CITY OF PORTLAND BUILDING PERMIT

Located At 36 BROOKSIDE RD

Job ID: 2012-11-5340-ALTR

has permission to Rear deck construction

PROPOSED DECK

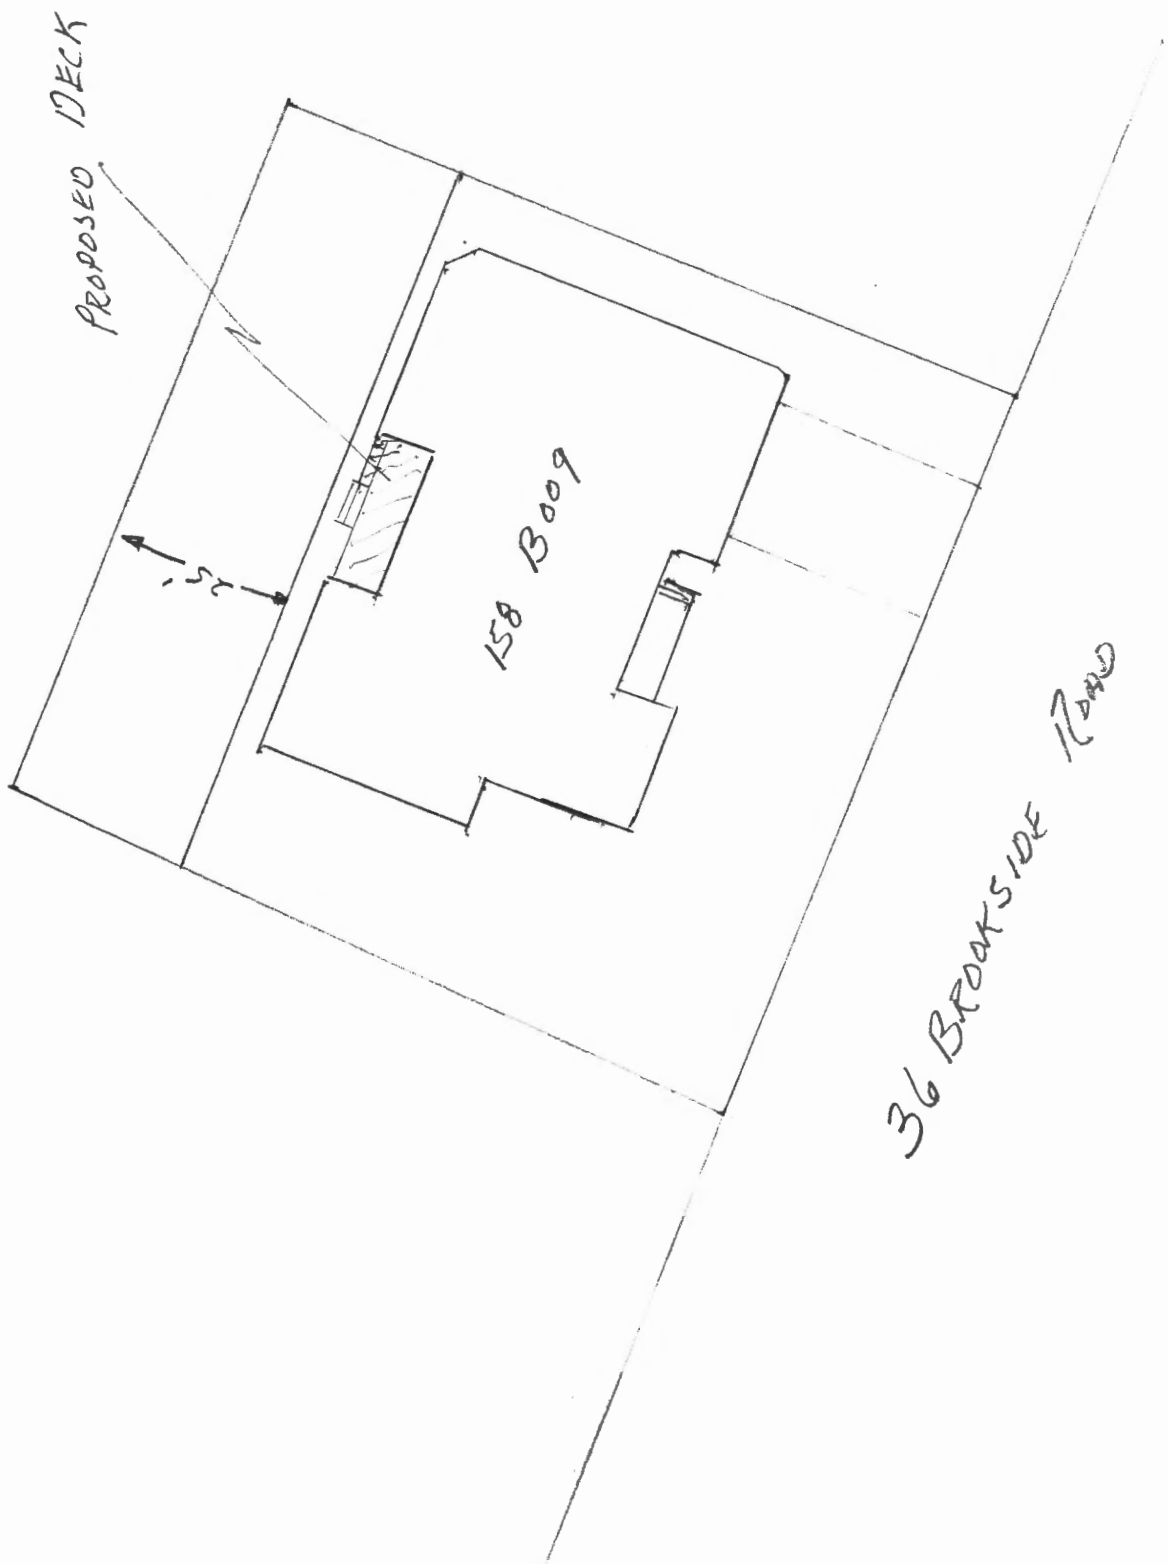
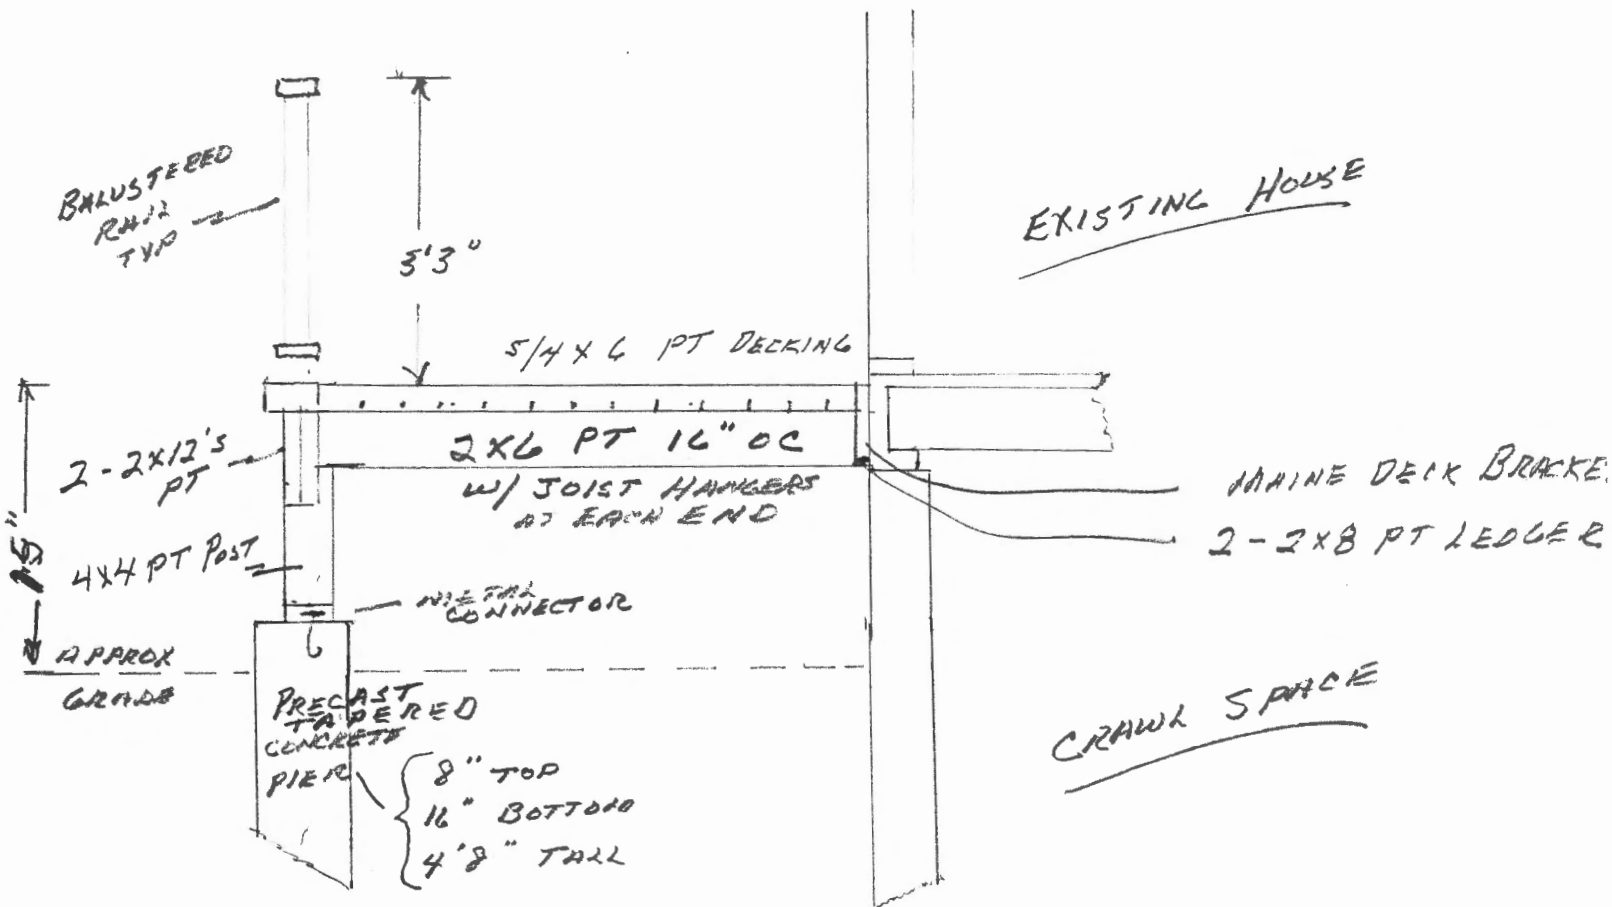
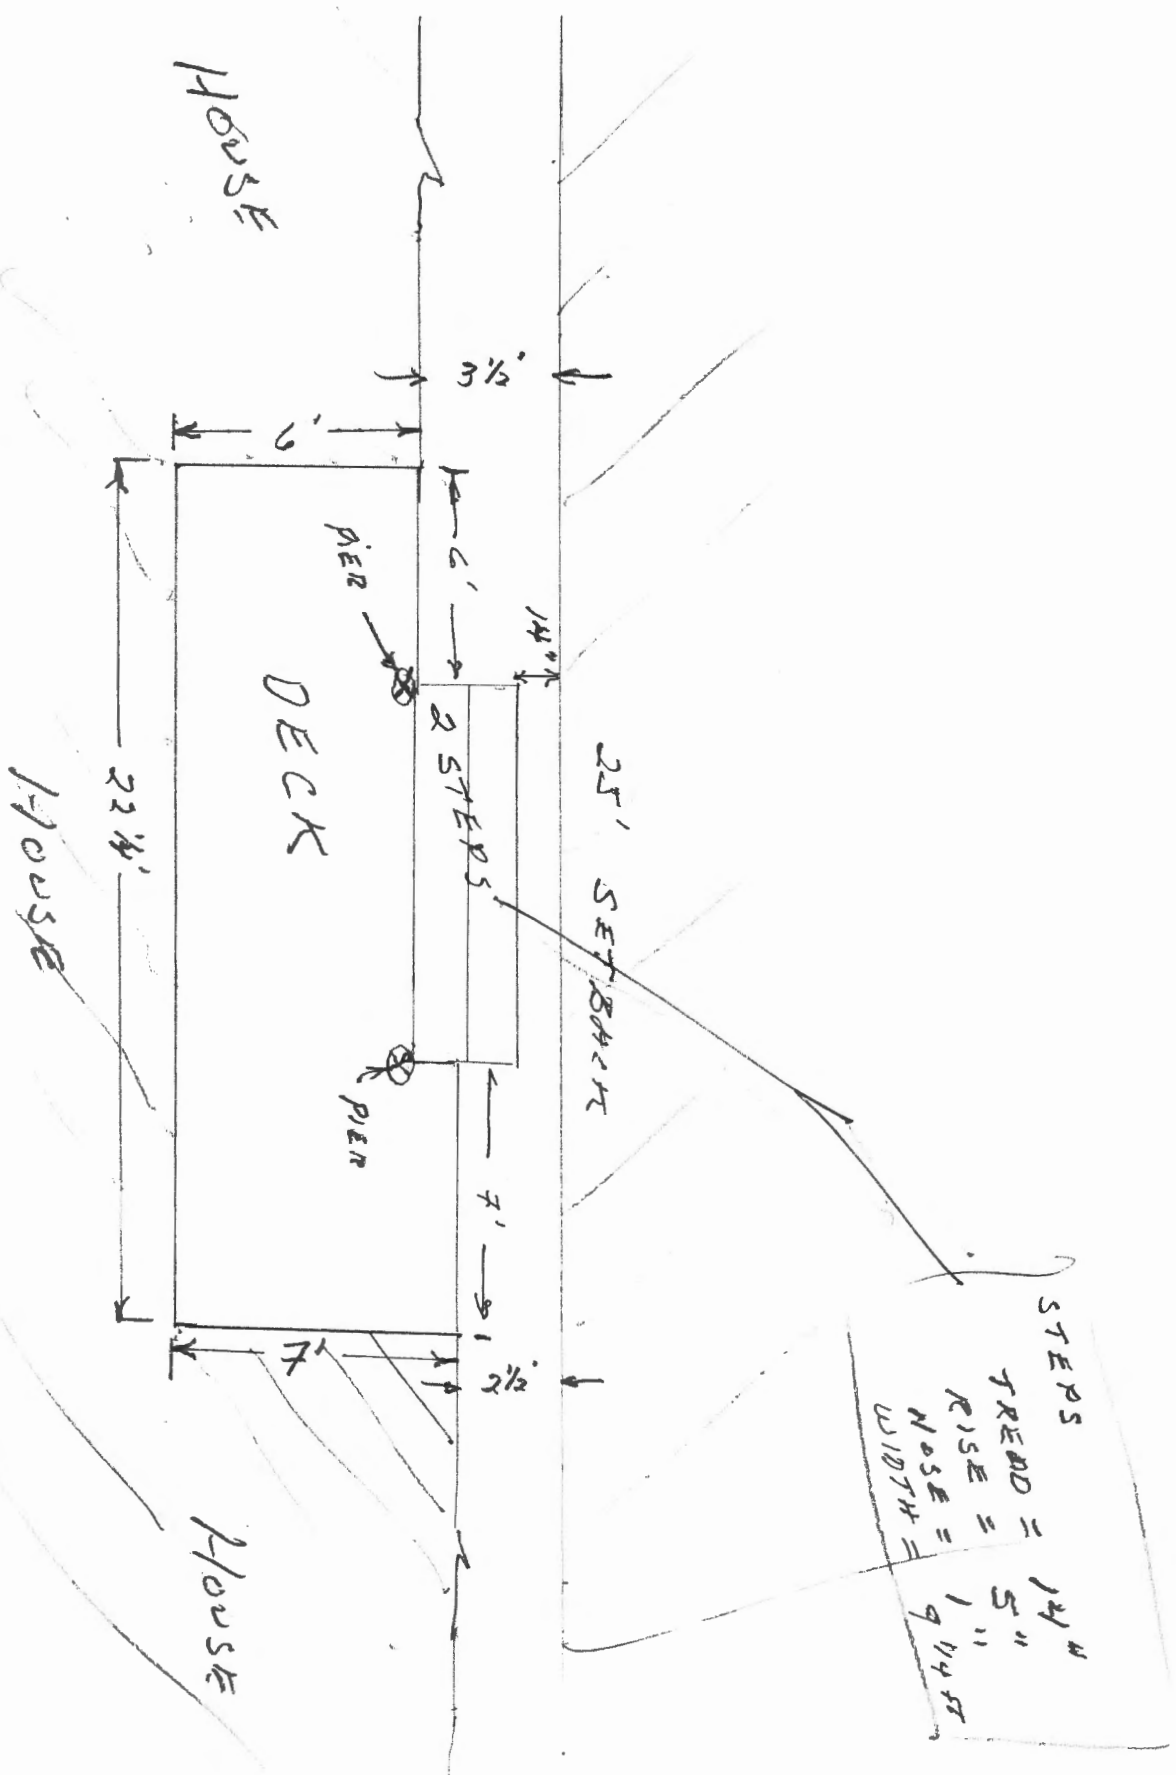
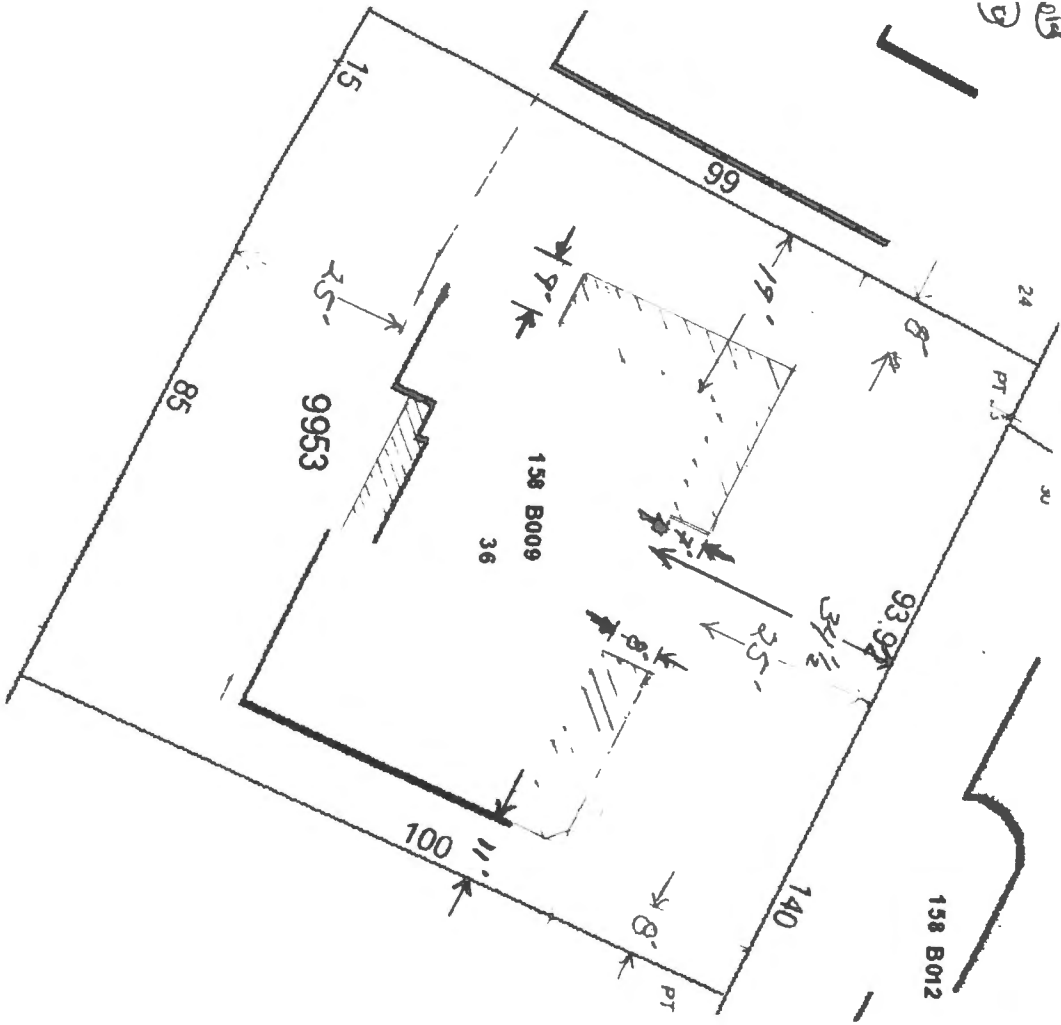
The maximum span for 2- 2" x 12"-s is 13'-6".
